# M25 junction 28 improvement scheme

TR010029

## 9.101 Applicant's response to Transport for London's Deadline 6

May 2021

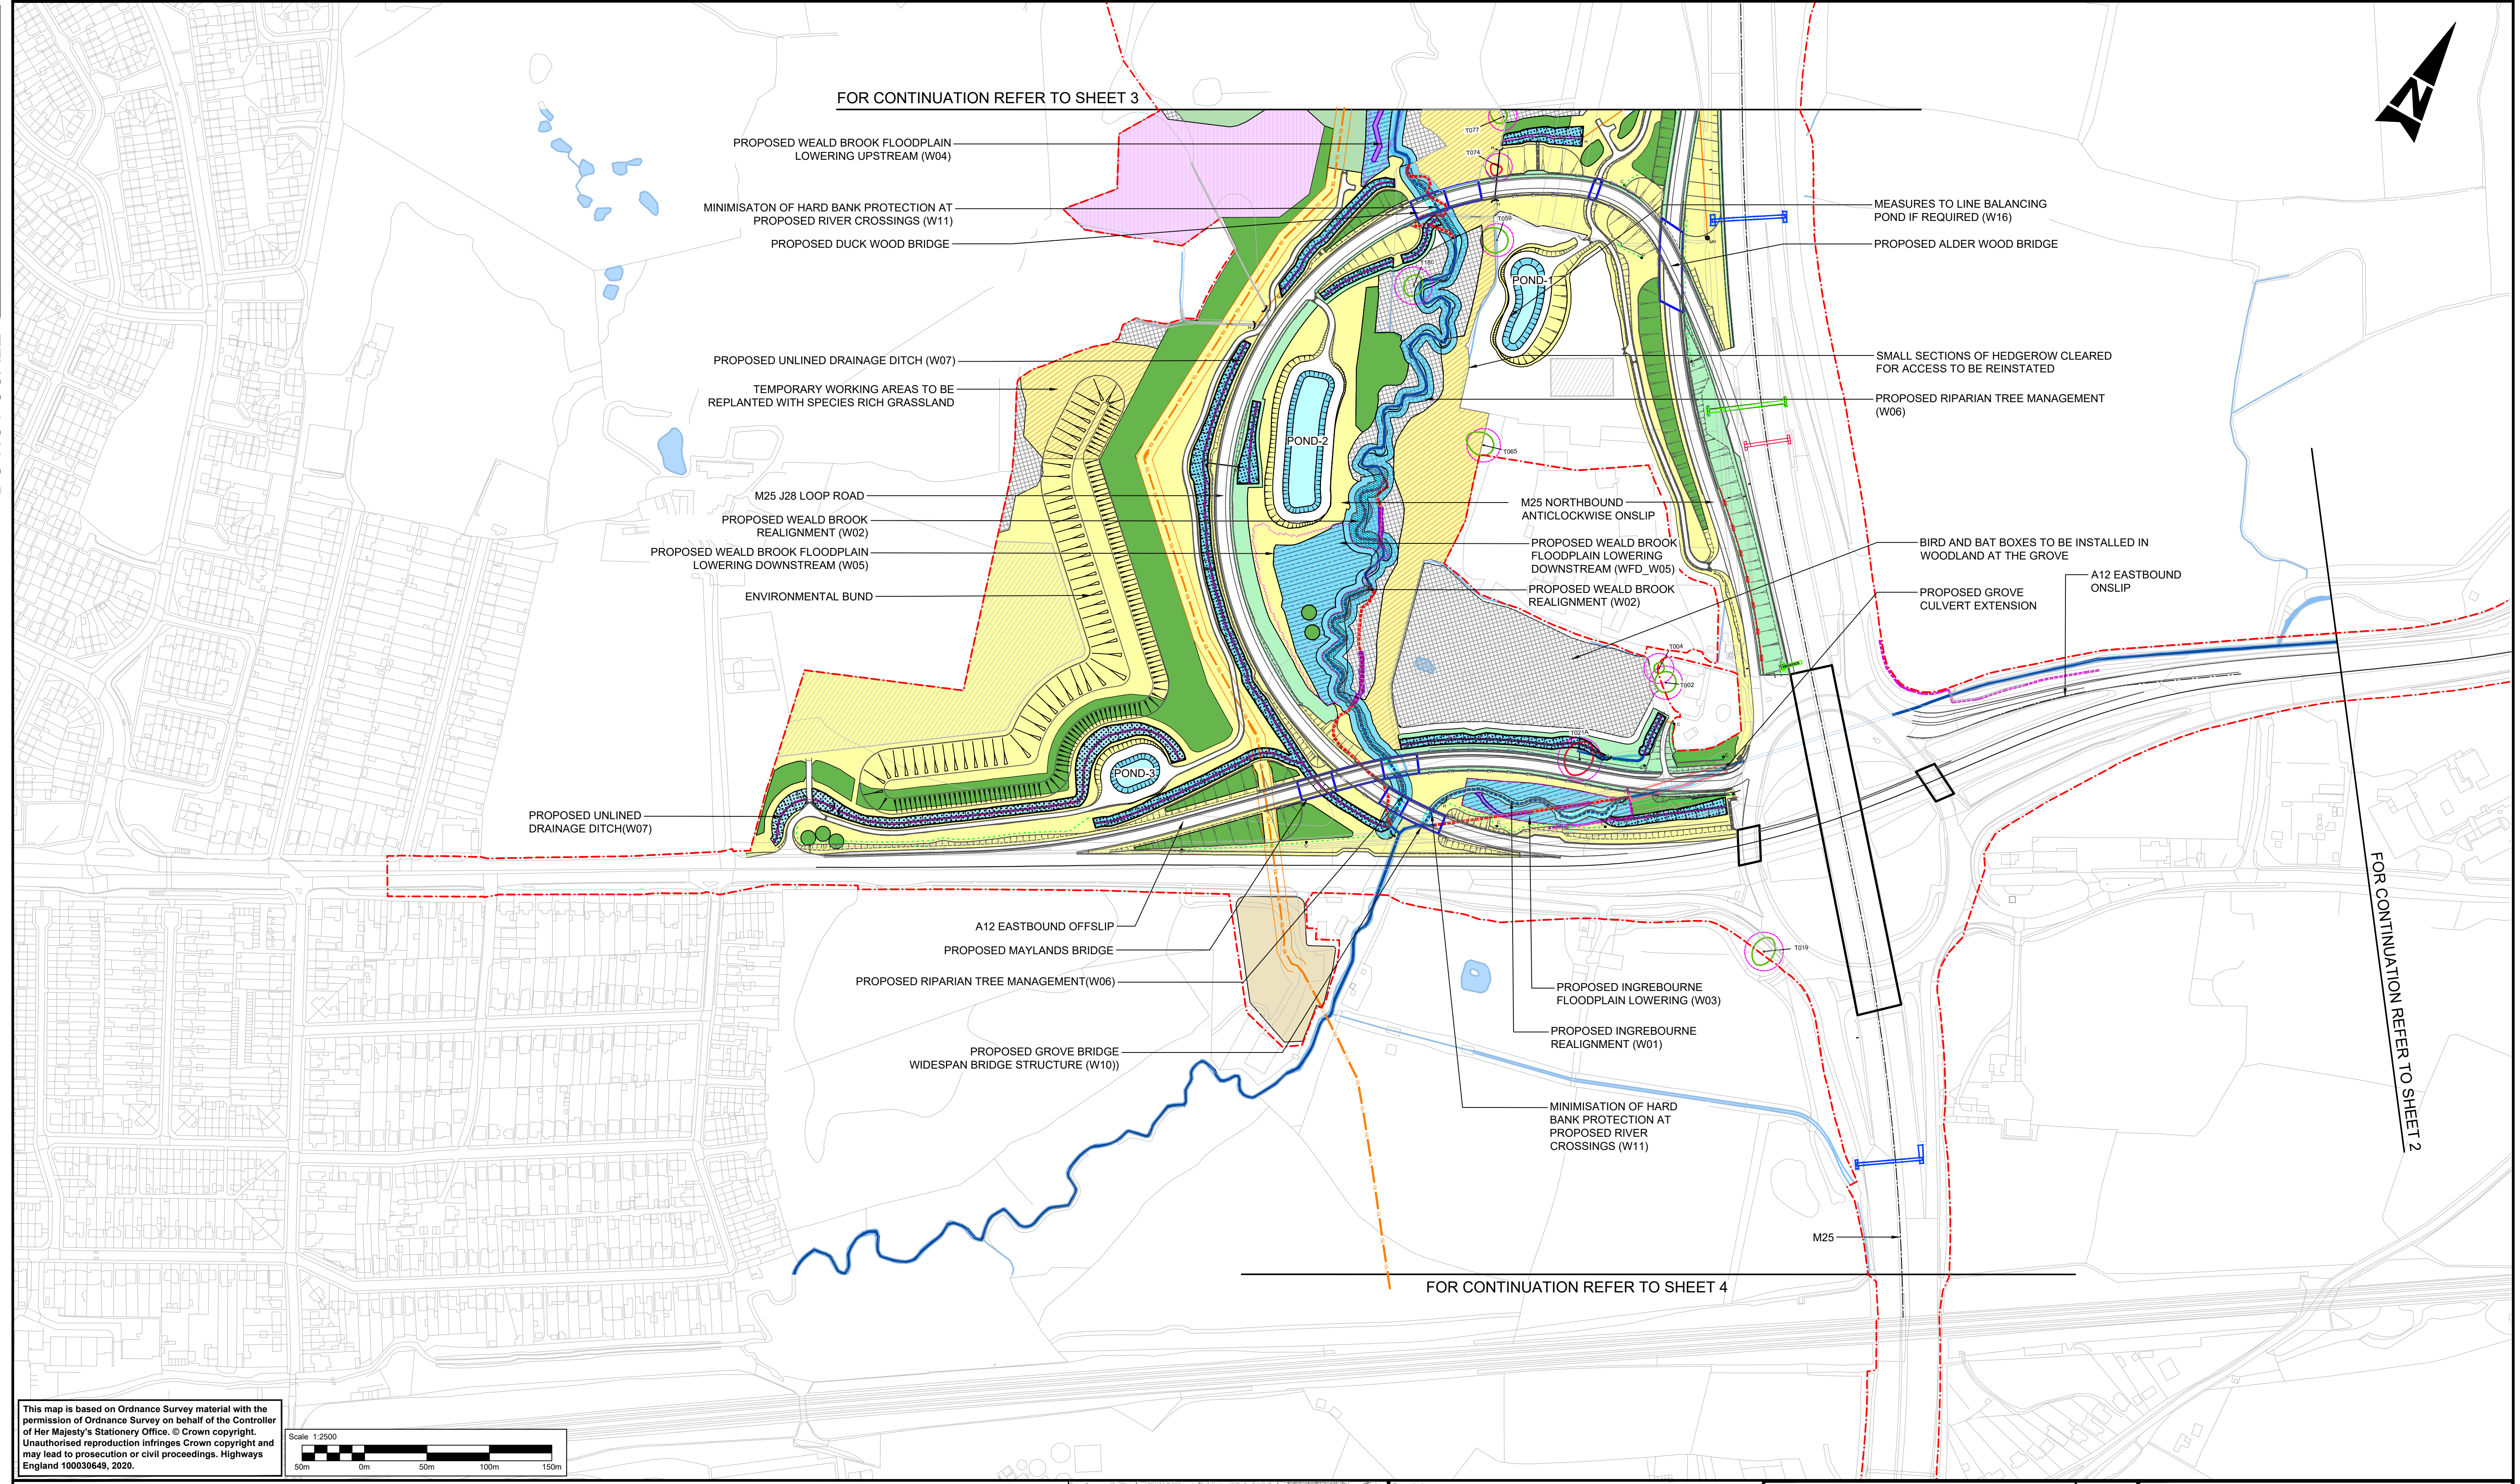
| Response reference: | Representation Issue  | Highways England Response  |
|---------------------|---|--|
| REP6-044-15         | <p>Regarding the planting proposed by the Applicant on the earthwork slope of the new A12 eastbound off slip embankment for visual screening purposes, TfL will require assurance that planting trees at the top of an embankment constructed as proposed will not affect the stability of the embankment and will not therefore impose additional maintenance requirements on TfL.</p> | <p>It would be best practice and recommended that tree species are set back from the top of the embankment to avoid potential encroachment into the transport corridor. The native woodland mix contains a mix of tree species (70%) and shrub species (30%), the recommended approach would be to plant these shrub species at the top and bottom of the embankment with tree species planted within these groups. The expectation is that the embankment would be constructed to avoid instability and at a suitable gradient (1:3) to allow the proposed planting to be implemented.</p> <p>Requirement 5(2) of the dDCO states that TfL will be consulted on the landscaping scheme which will reflect the Preliminary Environmental Design as shown on the Figure 2.2 (REP5-020).</p> |
